**Wincote**

**Design and Access Statement Addendum**

1.1 This document outlines the Minor Material Amendments to the previous application at Wincote, Cow Lane, Steeple Aston, Oxfordshire. OX2 4SG.

Title
Planning
Proposed
West & East Elevations

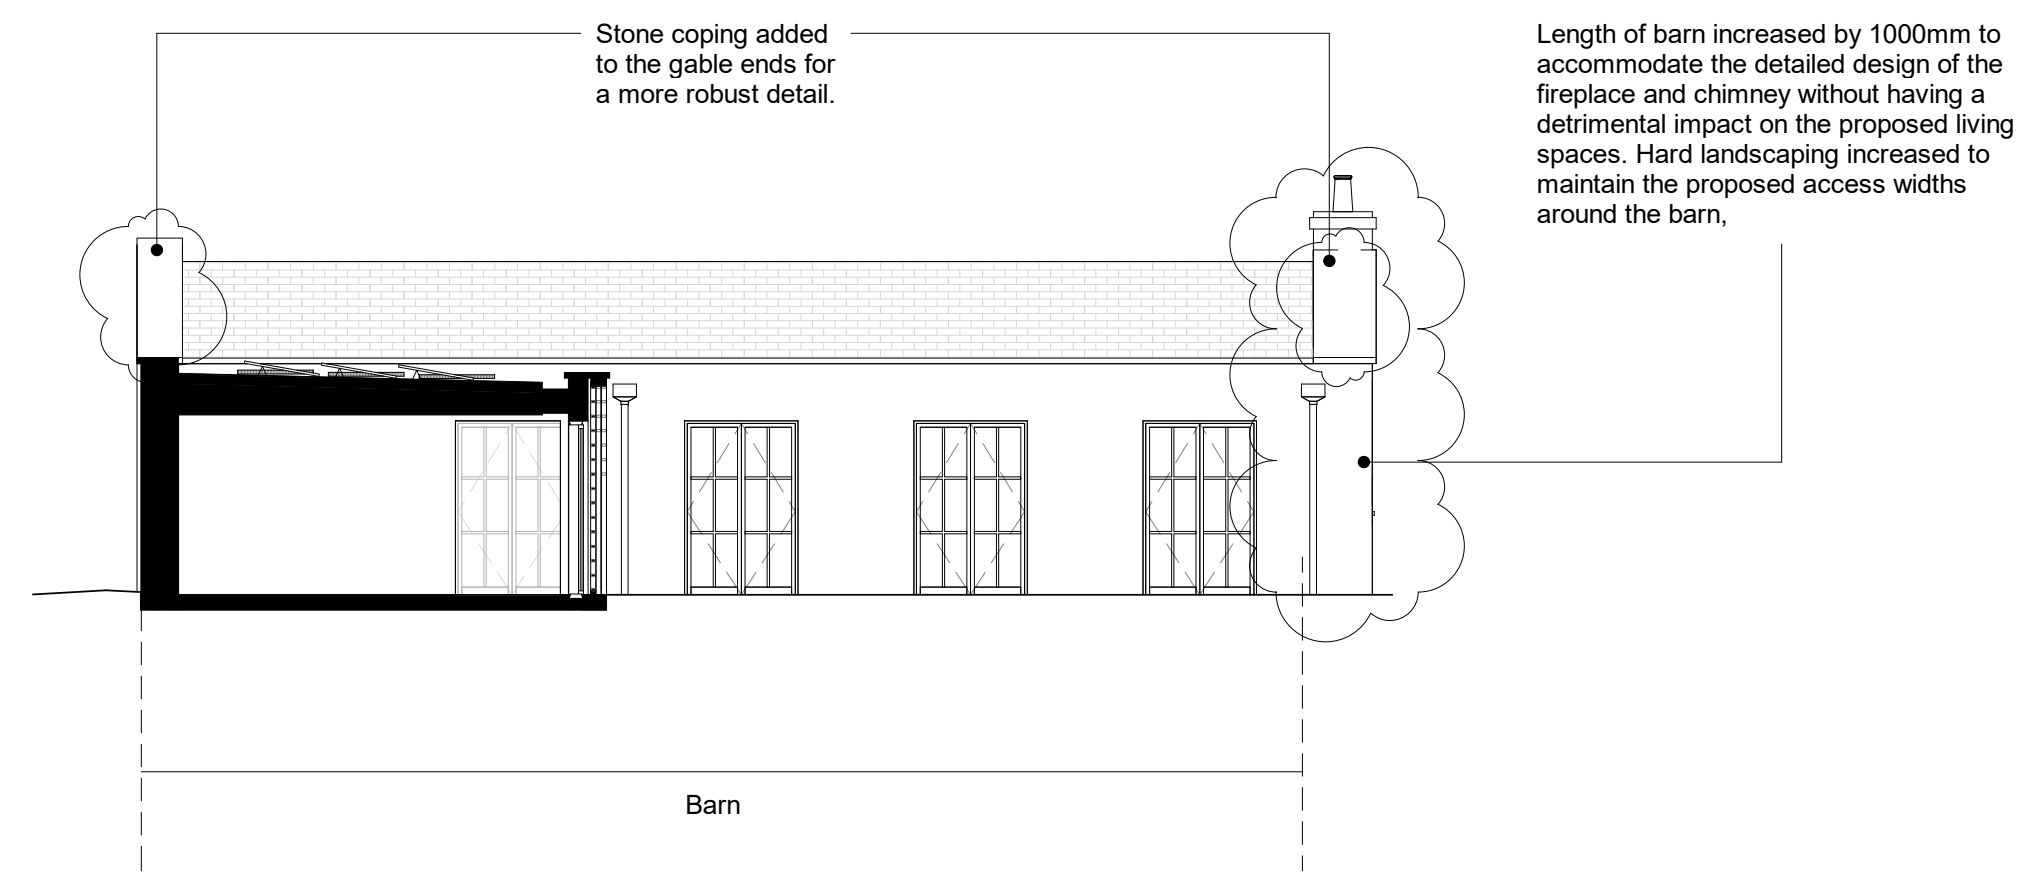
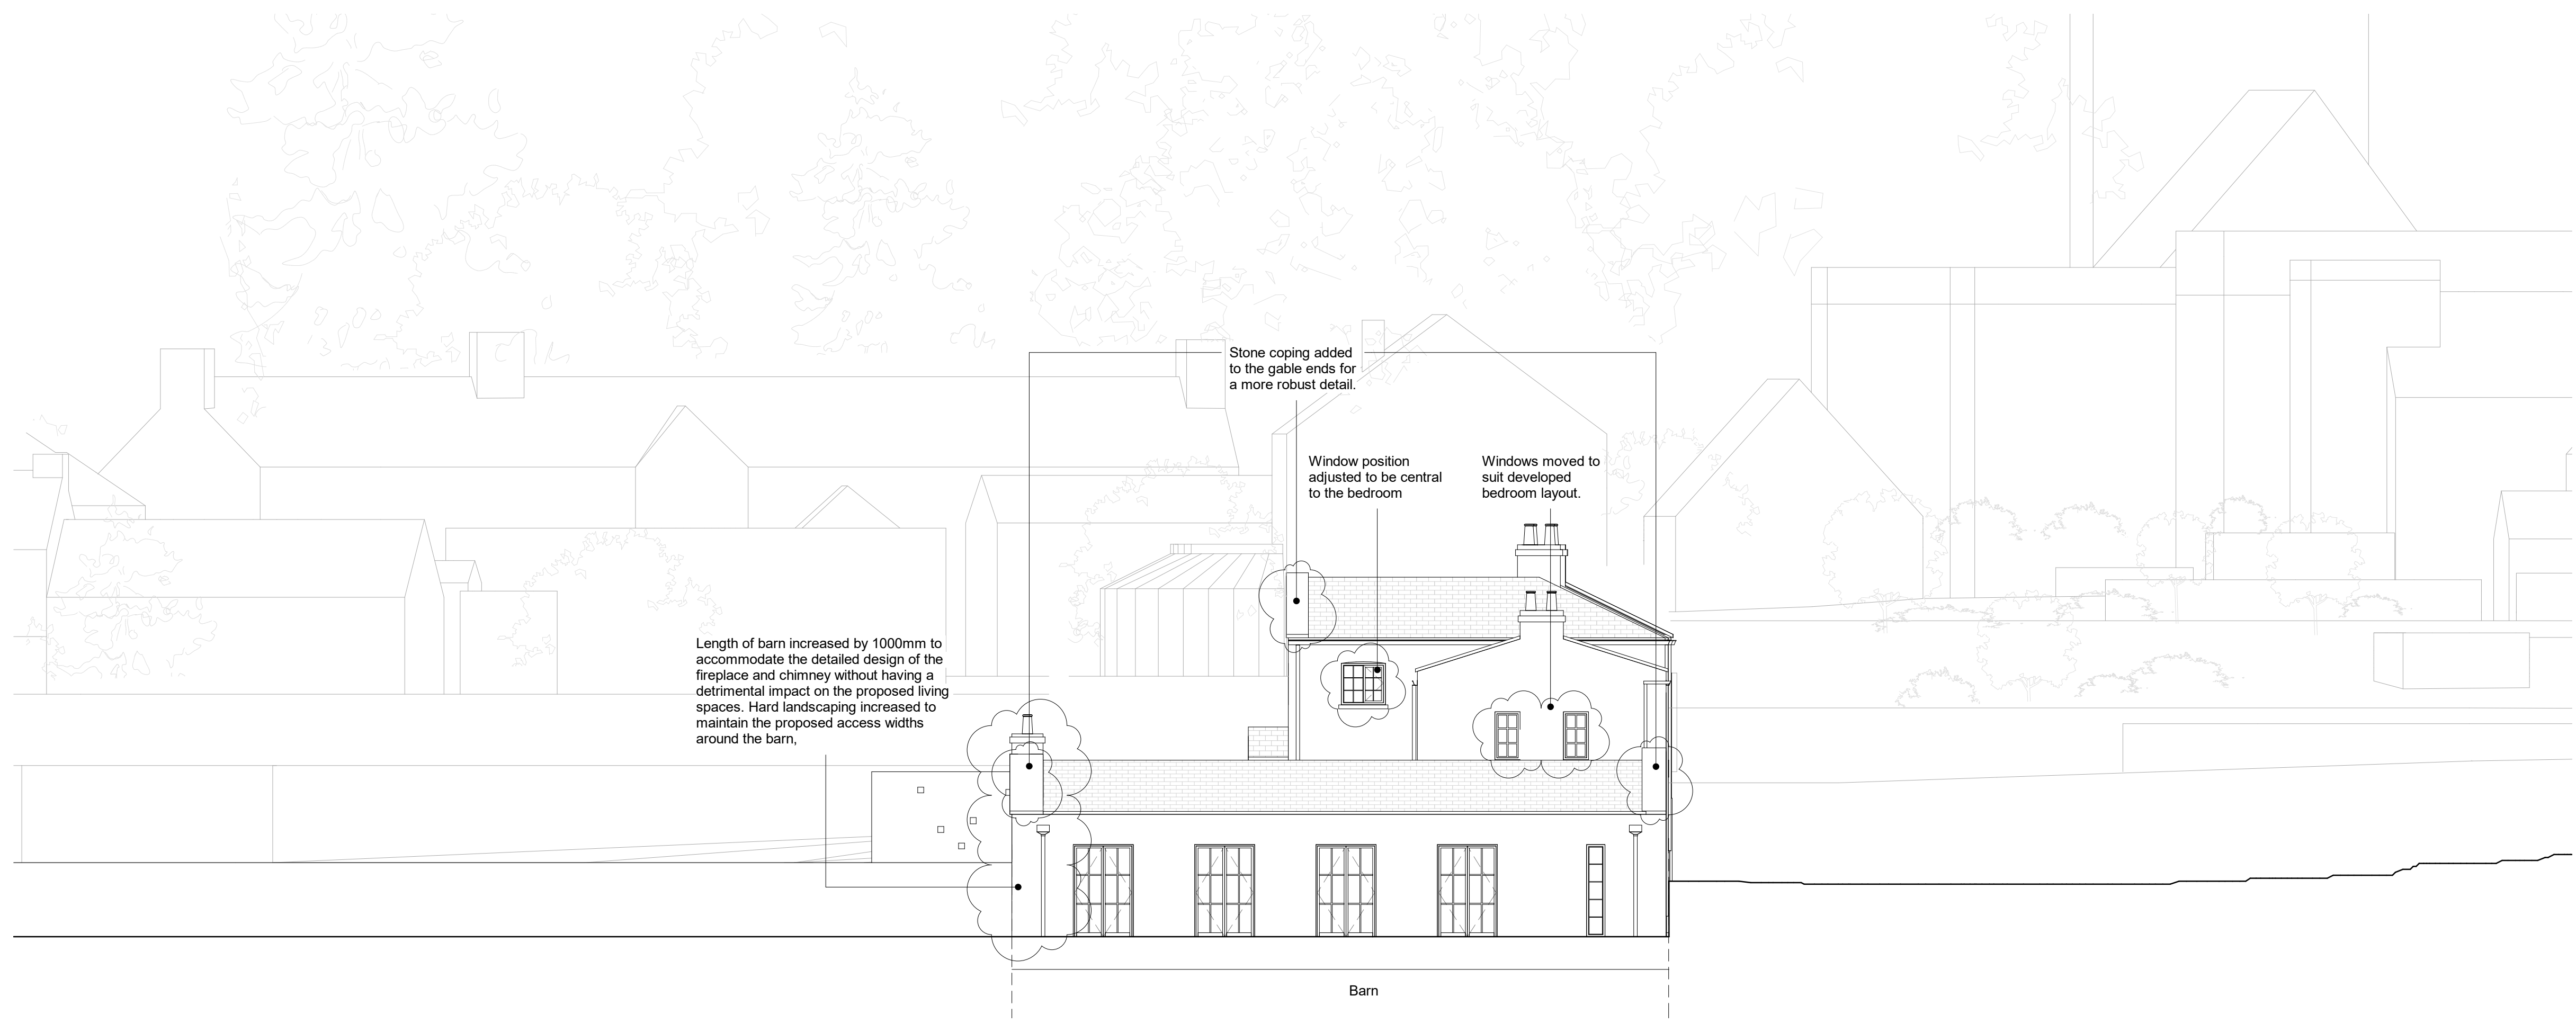
#### **4.4 Amendment to Master Bedroom windows on first floor east**

4.4.1 It is proposed to reduce these two windows in plan due to internal interior design development. They are also to adopt the crittle style to match the rest of the property.

#### **4.5 Amendment to the first floor south bedroom and entrance hall windows on the east and west elevations.**

4.5.1 It is proposed to centre these windows to the bedroom to better suit the internal interior design.

4.5.2 The entrance hall windows at ground floor are to also move to maintain the alignment.

4.6.2 It is proposed to increase the windows on the east and west elevations in plan for improved natural light into the space and due to internal interior design development.
